Our Reference: SYD18/01322/23

Departments Reference: SSD 9522

RESPONSE TO SUBMISSIONS ADDENDUM - KEMPS CREEK WAREHOUSE, LOGISTICS AND INDUSTRIAL FACILITIES HUB (SSD 9522)

MAMRE ROAD

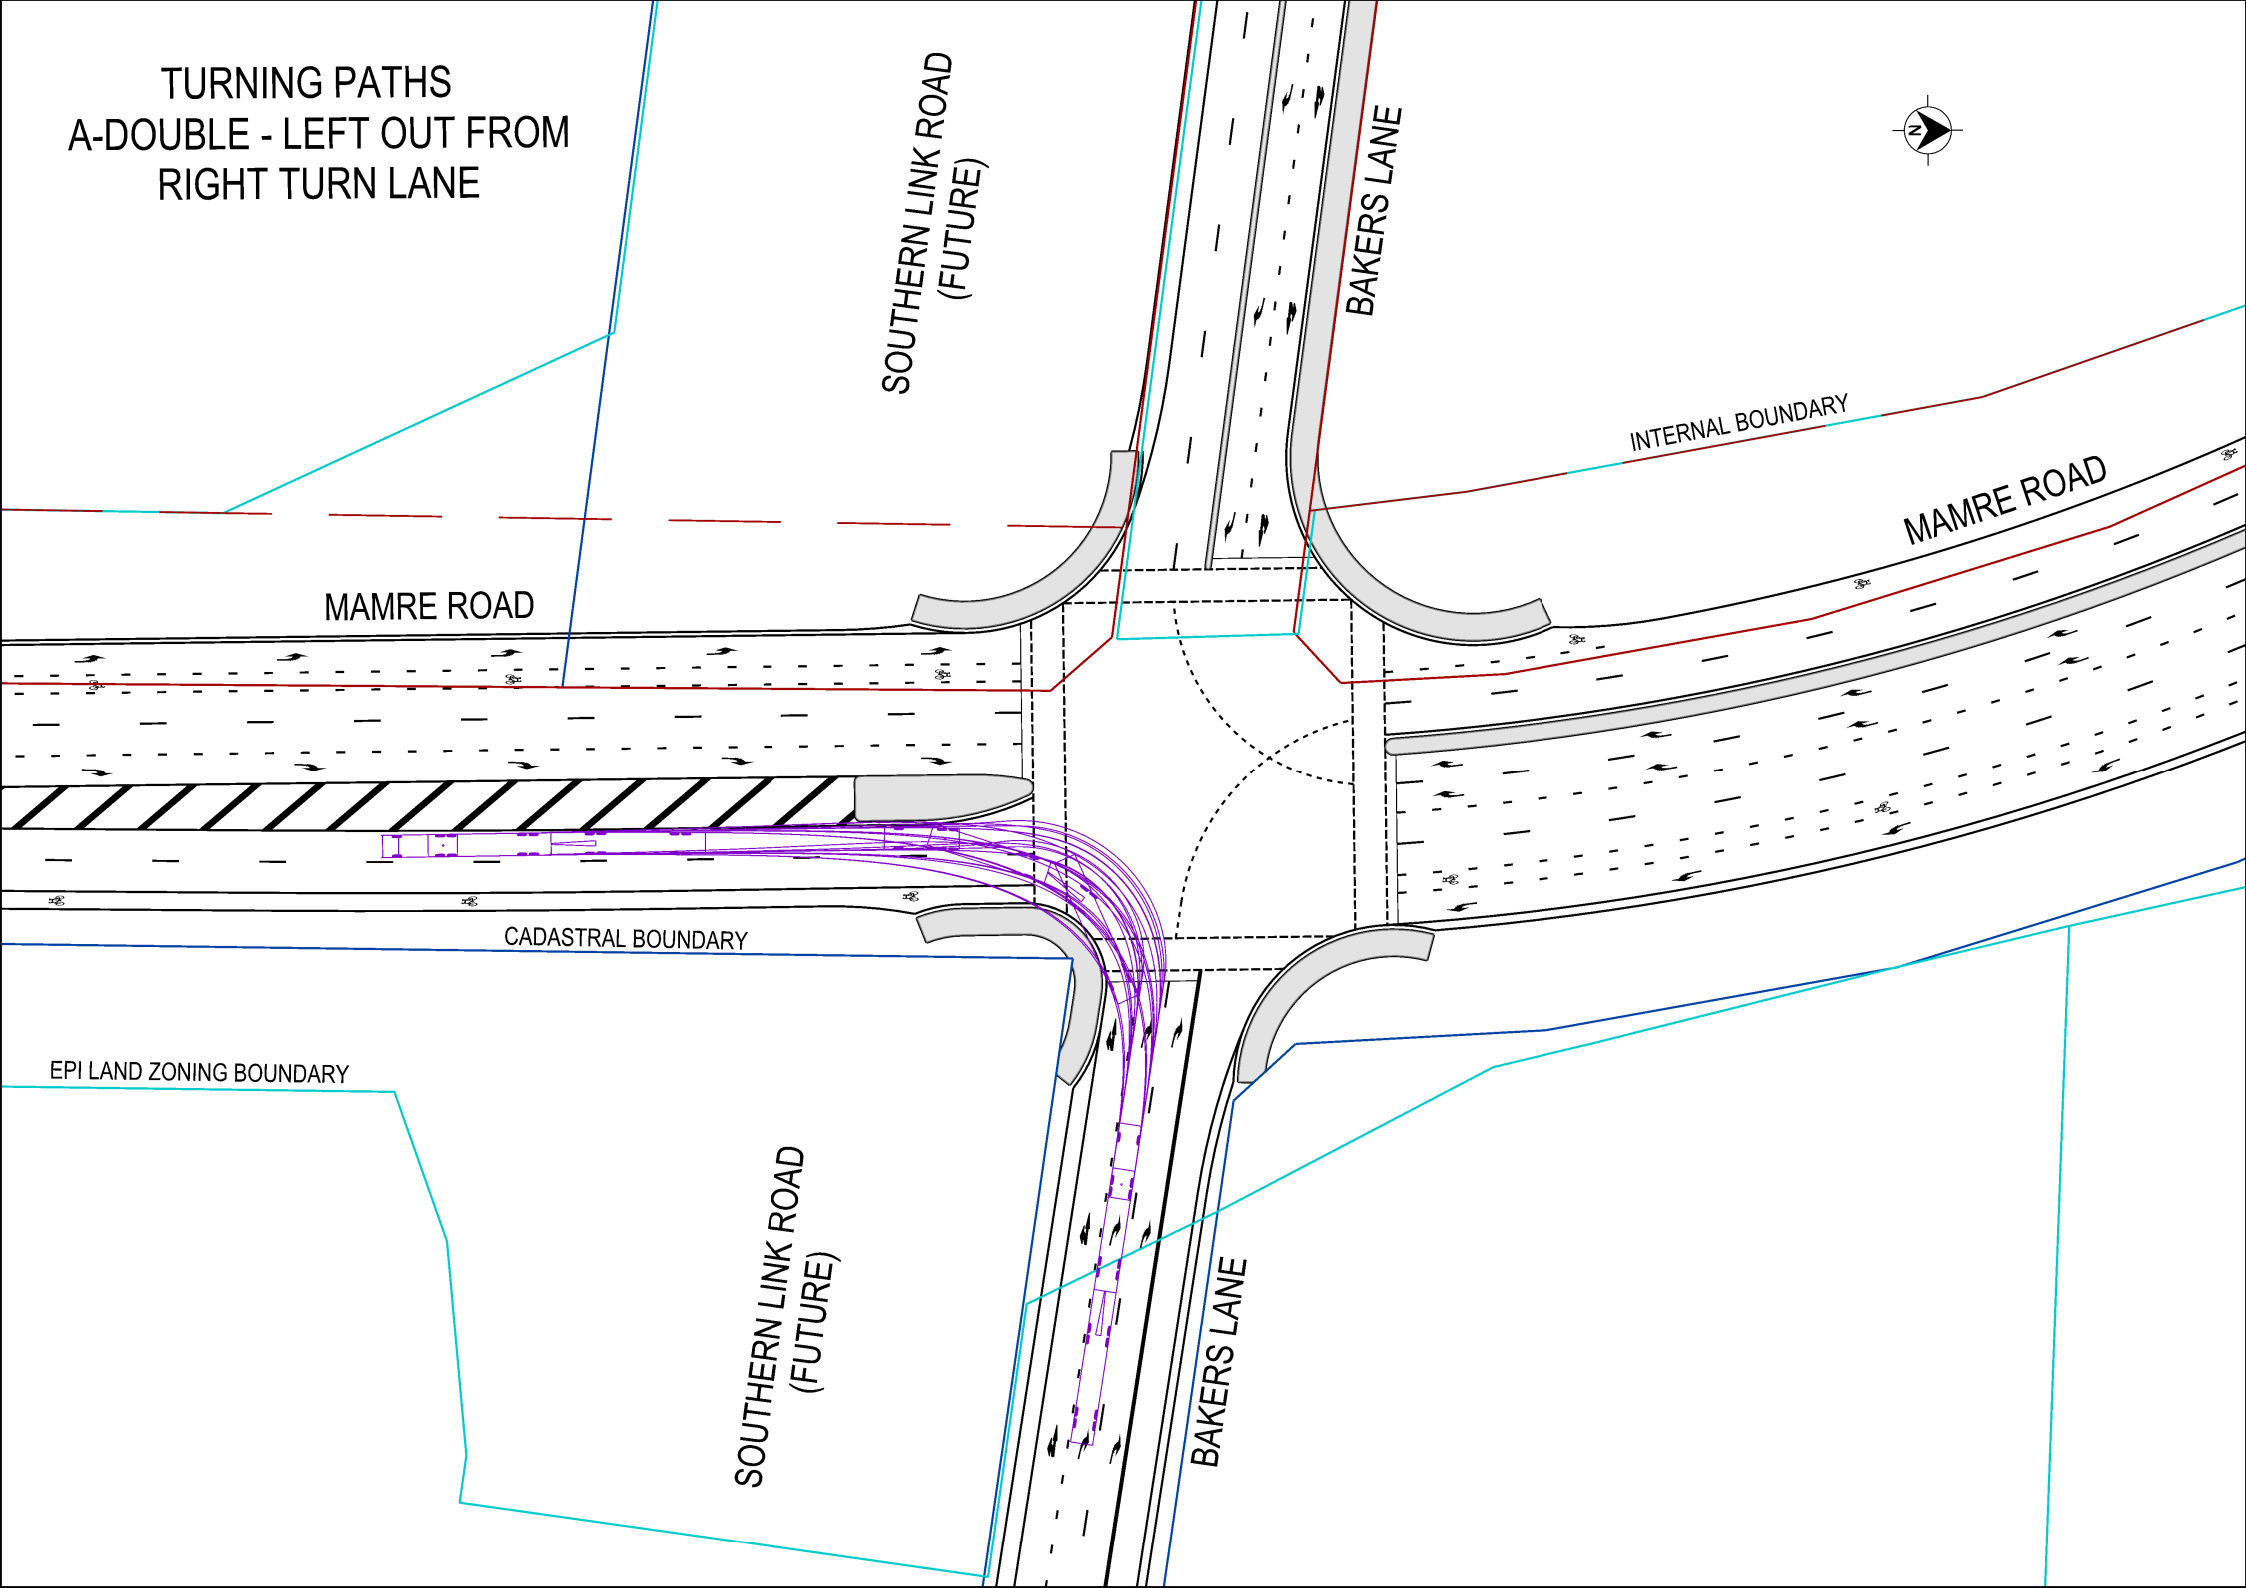
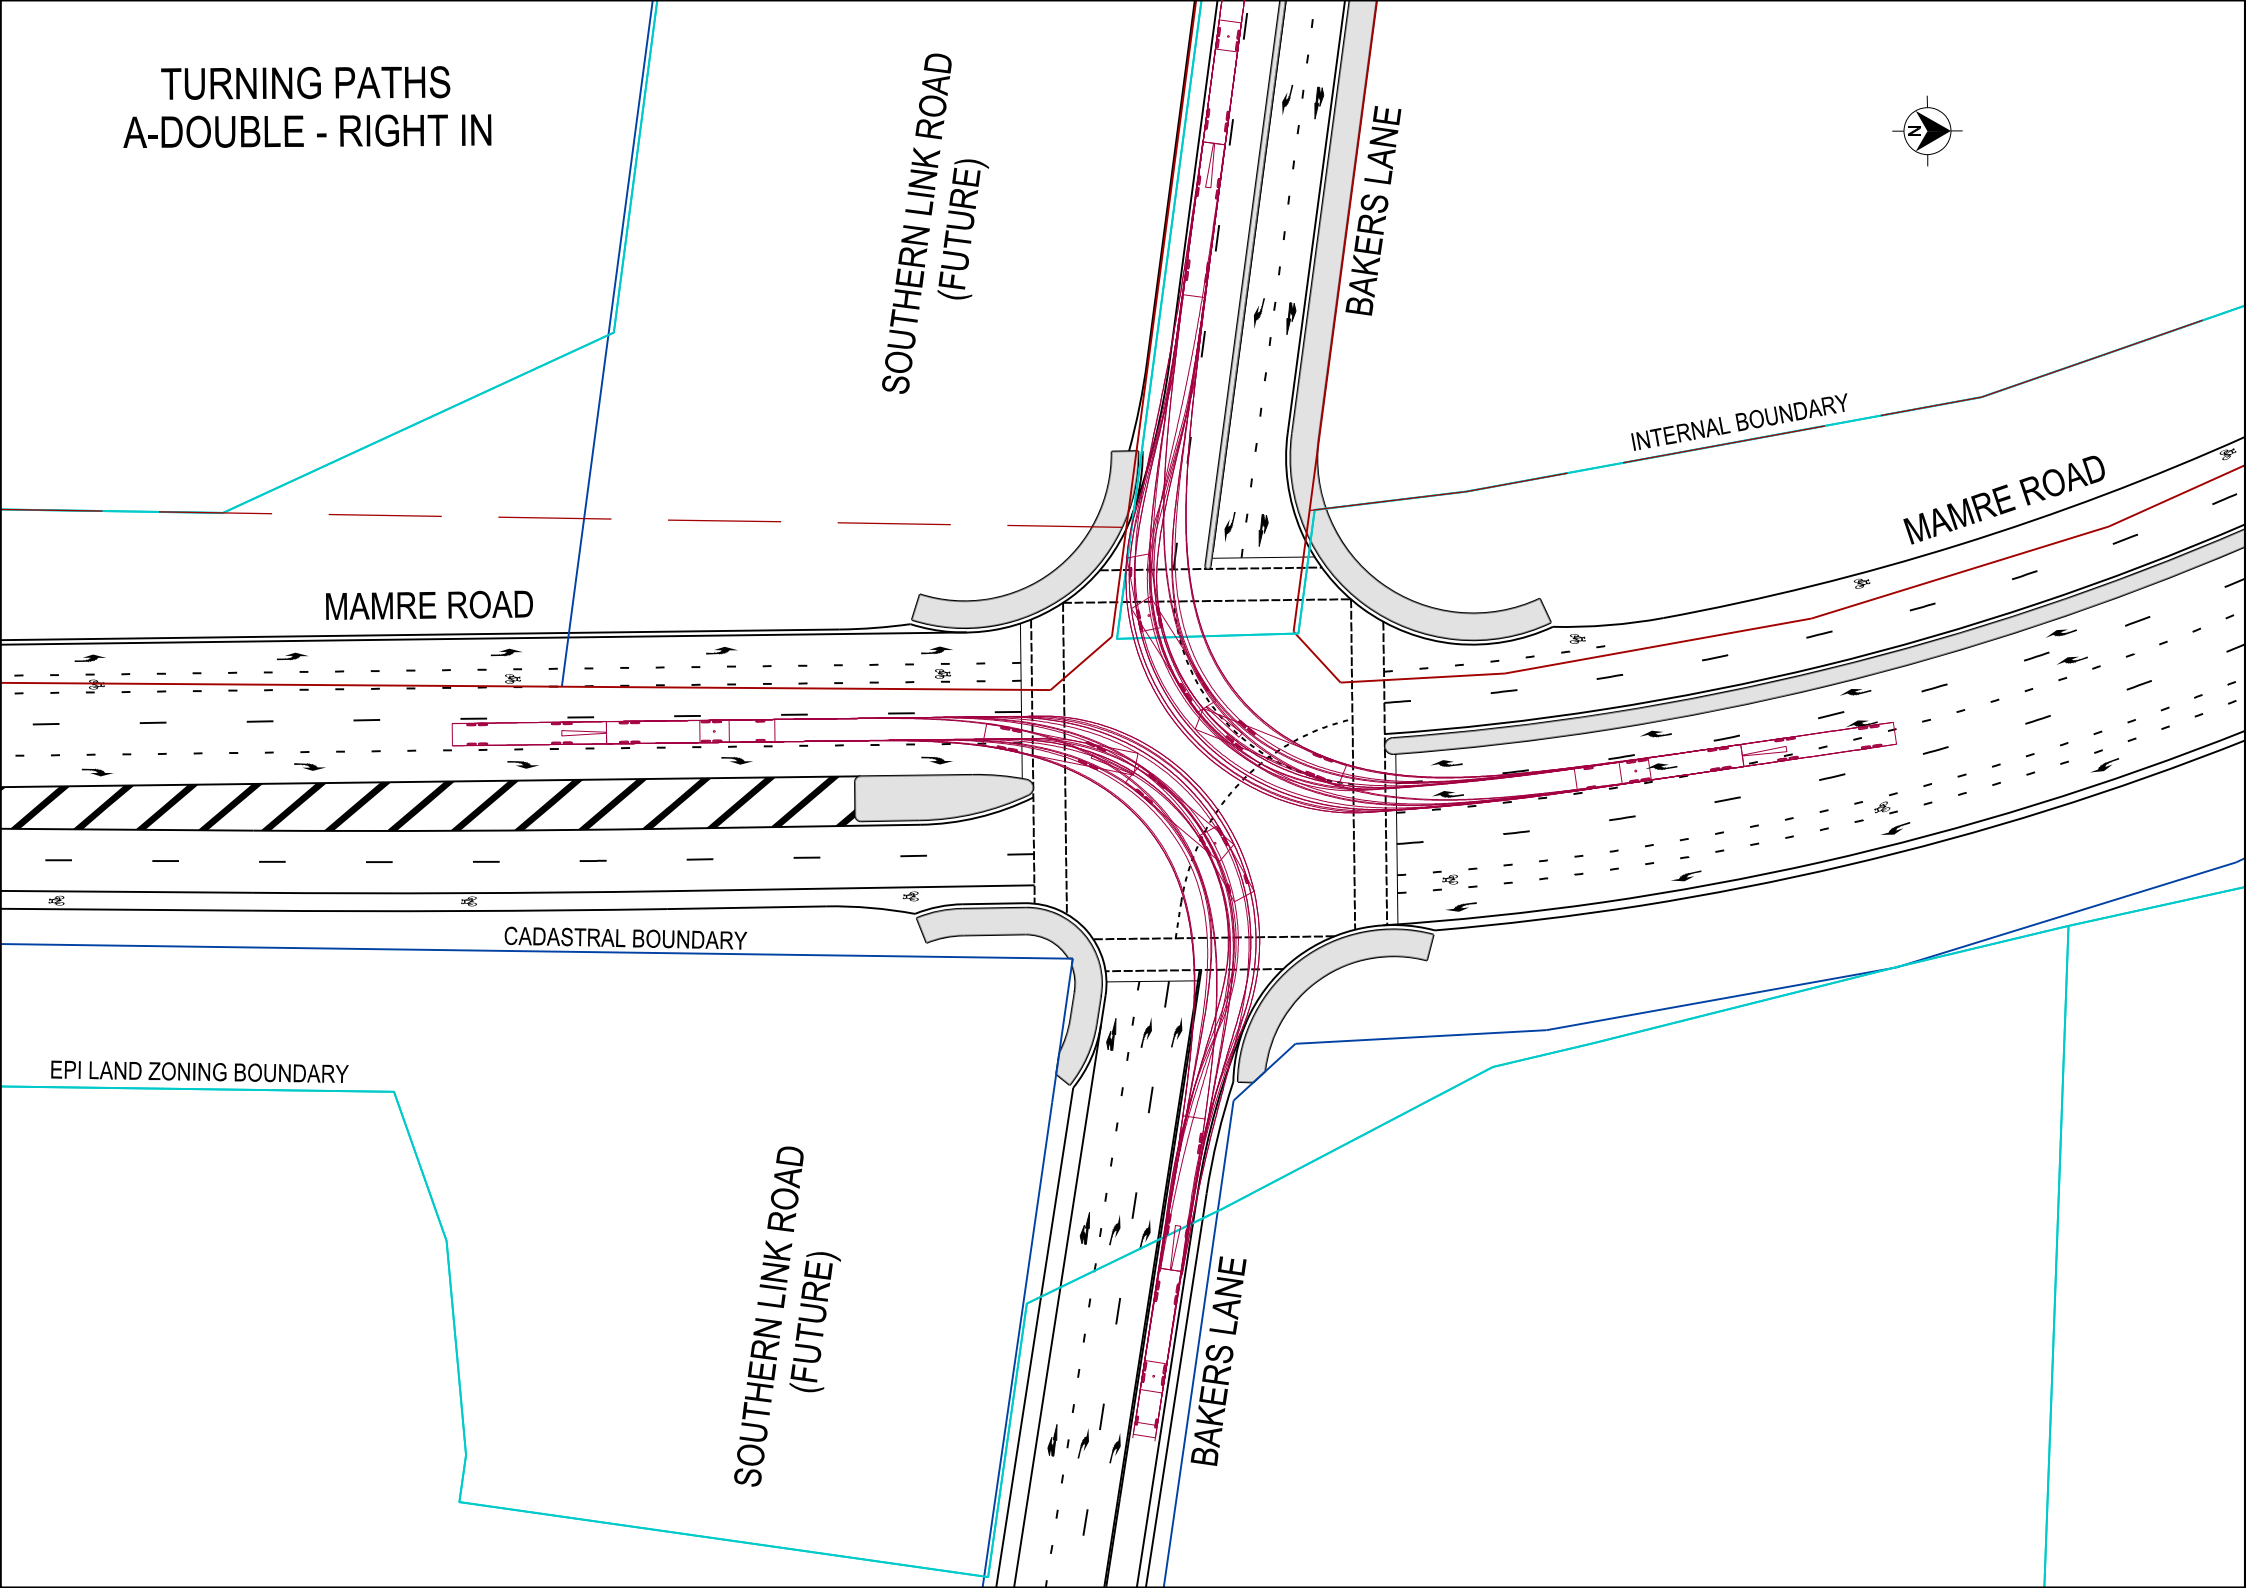
- i. Concept (or Strategic) Civil plans
 - ii. Draft Traffic Control Signal (TCS) plans
 - iii. Swept Path Plans
 - iv. Traffic Report – information is to be consistent with the actual proposed design
 - v. Warrant Assessment
 - vi. Land Owners Consent (If required)
2. In addition to the above point TfNSW provides the following high level design comment which is required to be incorporated into the design prior to further review of the intersection of Mamre Road/Bakers Lane. The swept path diagram provided indicates that the left turn into the Bakers Lane (east) is restricted to a 19 metre semi-trailer. As this is a new signalised intersection within an industrial land development TfNSW requires the whole intersection to be designed for a 26 metre B-double vehicle. Consideration should also be made in the design to accommodate for a PBS 3 Access Class A (36.5 metre) heavy vehicle.
